Dear Sir/Madam,  
Current Planning REF: LU/220/18/PL RE:70 High Street . Littlehampton.

The current planning application referred to above is due for determination however we have agreed a variation to the North elevation with your Conservation Officer Martyn White. We understand that he has consulted the case officer Anita Gardner and, as suggested, we enclose two prints of the revised drawing number 080418/TP.O4/BR01.REVISION 'C' for substitution prior to determination of this application.

SCALE / 1:100 @ A3
DATE / 12.06.2018
DWG. NO. / 080418/TP.04/A'

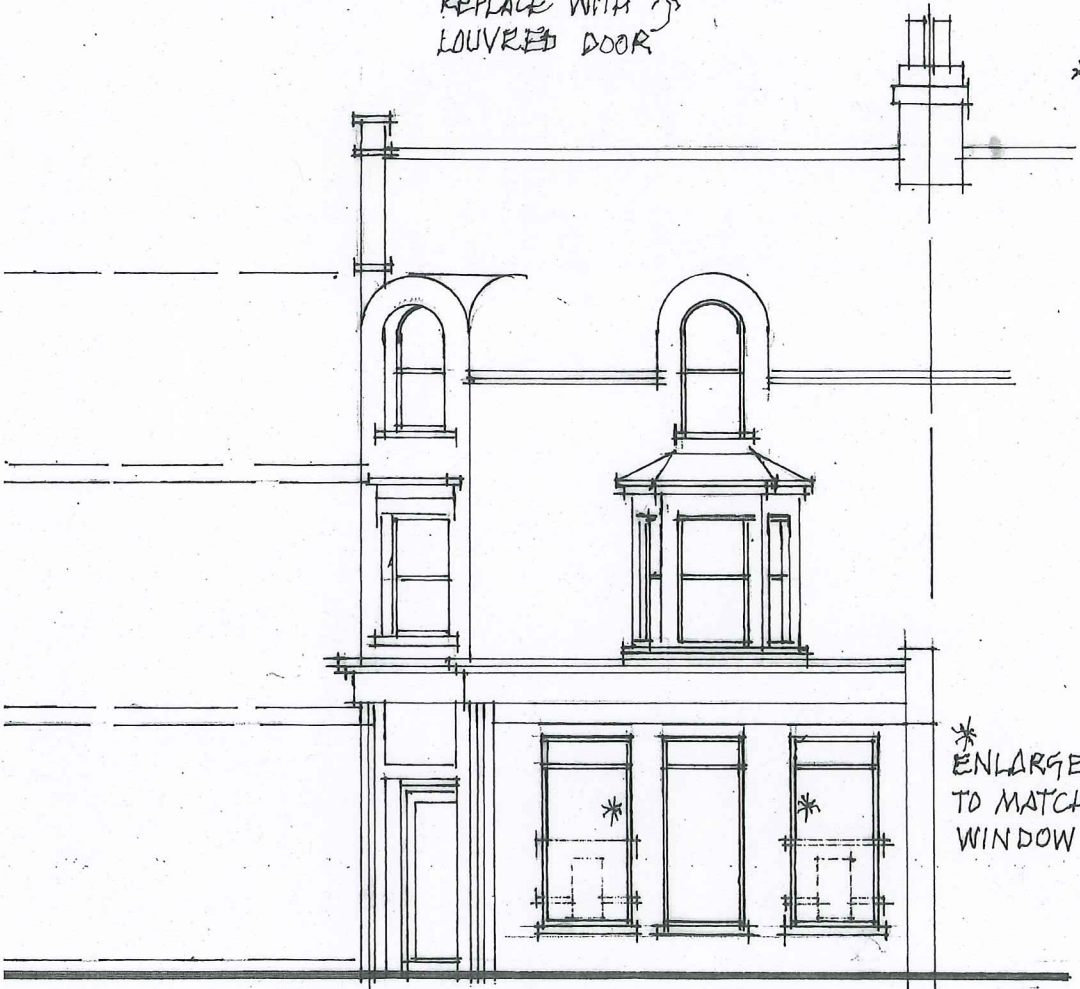
This shows the two side windows of the ground floor shop amended so that the cill line will be at the same level as the original cills.
